DRB Application No.: 07DRB-70286

Project # 1004414

Project Name: GIBSON TRACT A

RE: Lot 1, Gibson Tract A/minor plat

PLAT OF
 LOTS 1-A & 1-B
 GIBSON TRACT A
 PROJECTED SECTION 5, T. 10 N., R. 3 E., N.M.P.M.
 TOWN OF ALBUQUERQUE GRANT
 CITY OF ALBUQUERQUE
 BERNALILLO COUNTY, NEW MEXICO
 SEPTEMBER 2007
 SHEET 1 OF 2

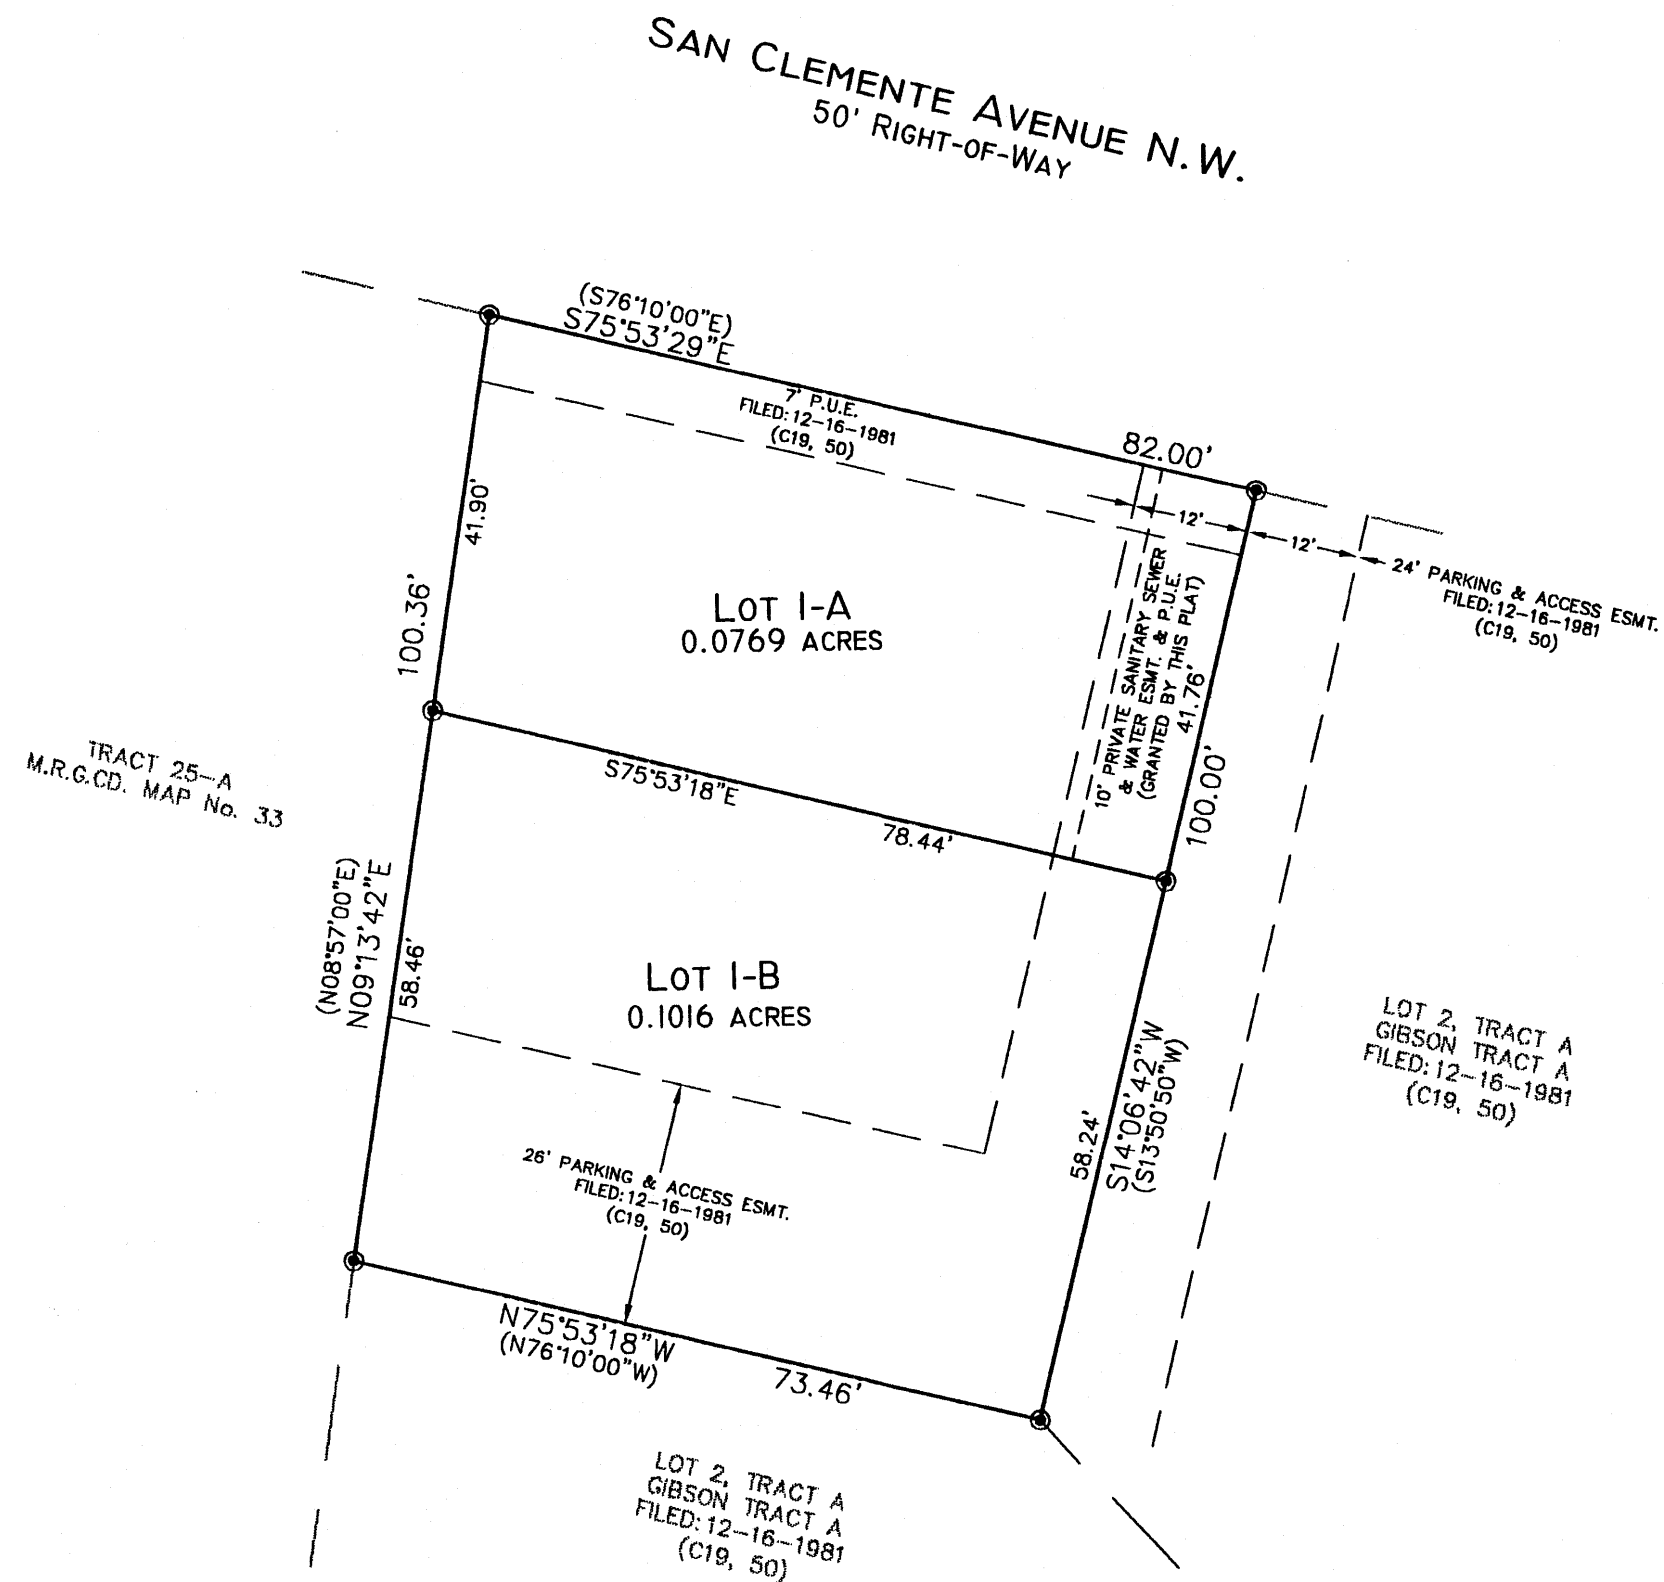
TRANSPORTATION: x access not (east lot has access)

A cross lot drainage easement is required.
